REQUEST

Current Zoning: R-3 (single family residential)
Proposed Zoning: UR-2(CD) (urban residential, conditional)

The petition proposes to redevelop the single family home site with a infill townhome community with up to 17 units on Providence Road south of Fairview Road.

STAFF RECOMMENDATION

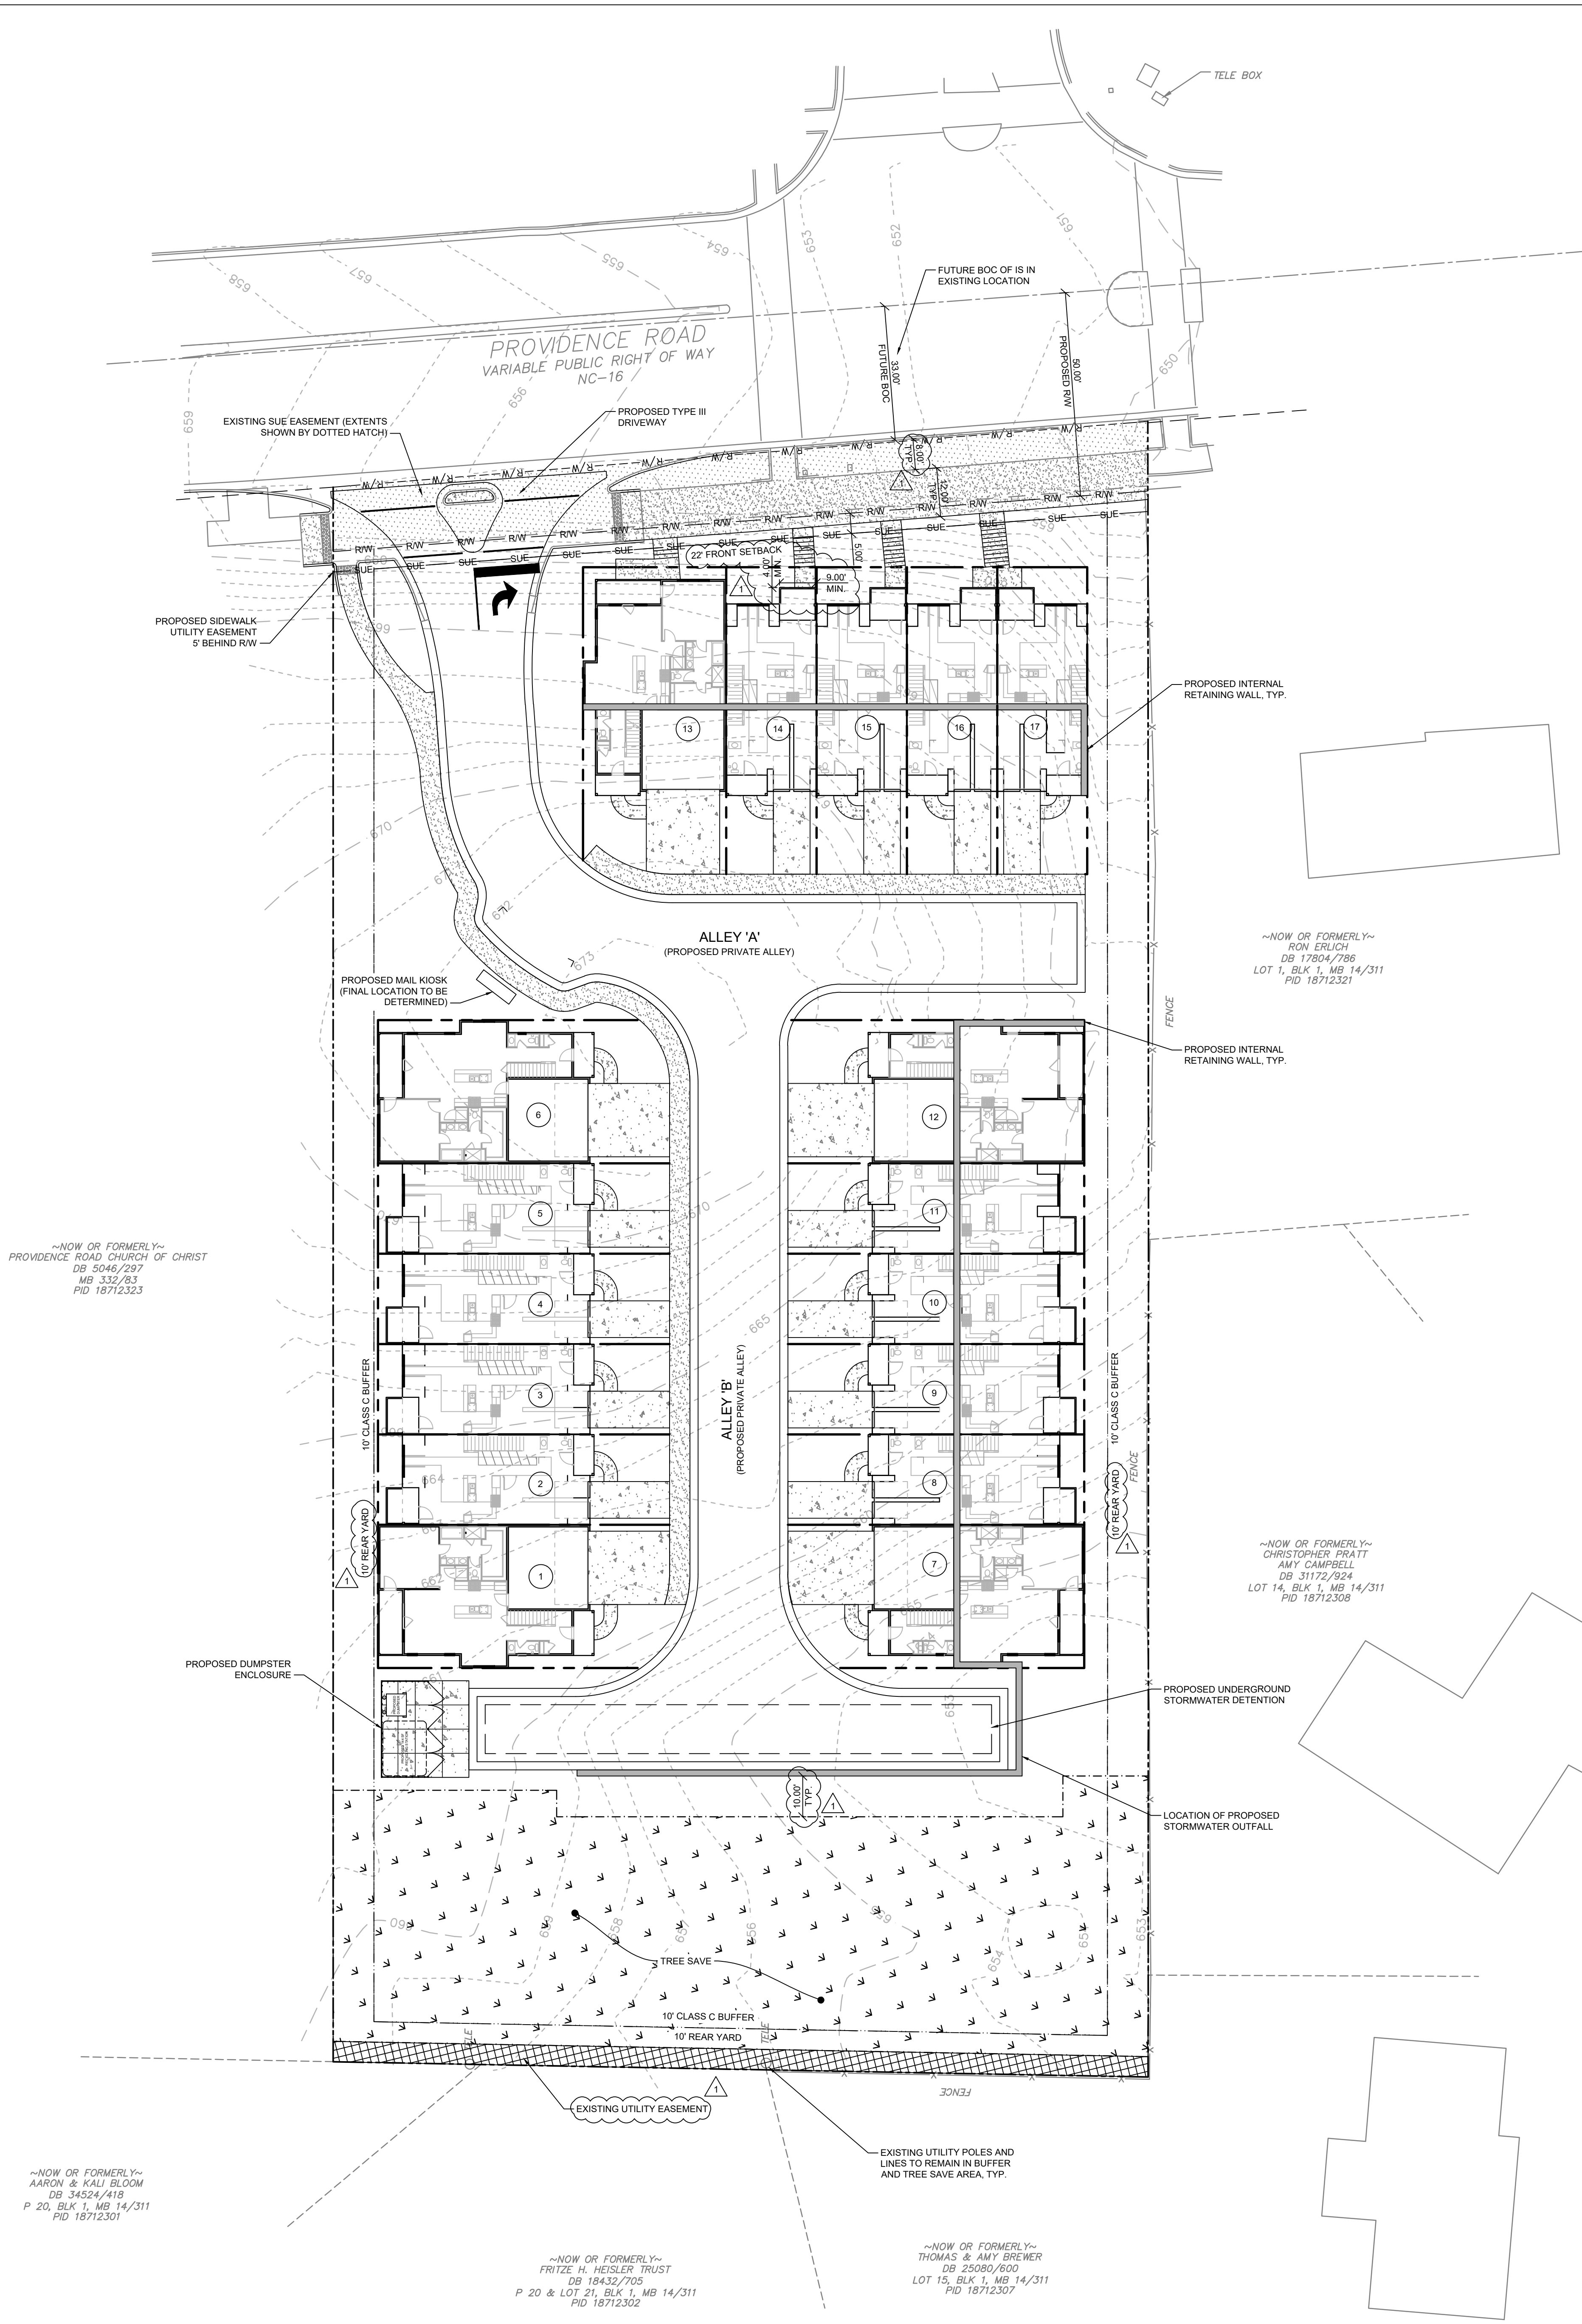
1. Extend the internal sidewalk to the end of Alley B in front of unit 1.
2. Increase the setback along Providence Rd to 40 ft measured from the future back of curb to be consistent with other rezonings along Providence Rd and to more closely resemble setbacks of other buildings along the street.
3. Architectural note 9 is not clear, amend to provide a minimum dimension for "recessed doors" (suggestion is 12"-24") and what explain what is meant by lights/high windows in doors. .
4. Amend note 5 under Architectural standards related to the facades facing Providence, as it is currently written it conflicts with note 4.

5. Adjust the site plan to show the future back of curb 33 ft from the centerline instead of 30 ft.
6. Add conditional notes to the site plan committing to the construction of the 8 ft wide planting strip and 12 ft wide multi-use path.

7. Label and dimension the 8 ft planting strip along Providence Rd.
8. Label and dimension the internal sidewalk.
9. Staff suggests reconsidering the proposed 6x9 stoop side requirement or label as stoops as typical and say minimum 6x9.
10. Change the side yard labels on the north and south sides of the site to say "10' Rear Yard."

11. Adjust existing utility poles and lines or adjust the Tree Save area because utility poles and lines cannot be located within Tree Save areas.
12. Consider the addition of the requested Stormwater note related to concerns of stormwater runoff from this site to adjoining parcels.
